**Consultation Response from KC,  
Highways Development Management**

**2023/92700 Land at, Whitley Road, Whitley, Dewsbury, WF12 0LZ**

**Reserved matters application for erection of one dwelling pursuant to outline permission  
2020/93432 (APP/Z4718/W/21/3274396) for erection of residential development**

**Date Responded:13-11-2023.**

SITE / GROUND FLOOR PLAN

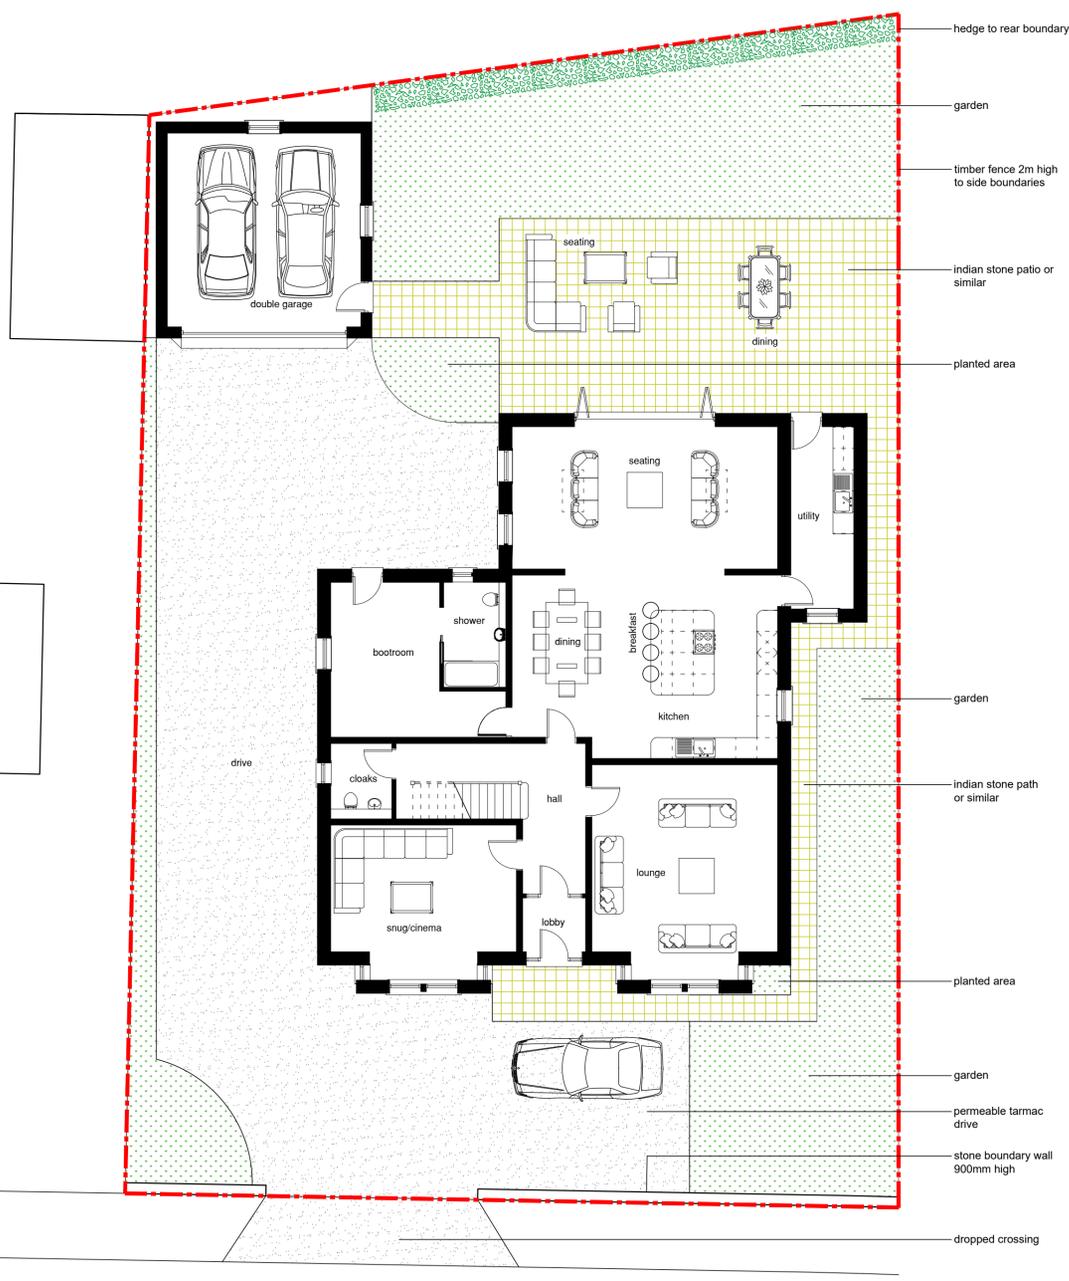
Pickles Architecture plan number N651 05 rev A shows a proposed four bedroomed detached house with detached double garage with a driveway accessed directly from Whitley Road. The driveway has sufficient space to allow interval vehicle turning and additional parking.

The stone boundary wall to the site frontage is shown to be 900mm high.

Given the planning inspectors comments these proposals are considered acceptable to Highways Development Management.

**Nothing to be ... within 2m.**

Nothing shall be permitted to be planted or erected within a strip of land 2.0m deep measured from the carriageway edge of Whitley Road along the full frontage of the site which exceeds 1.0m in height above the level of the adjoining highway.
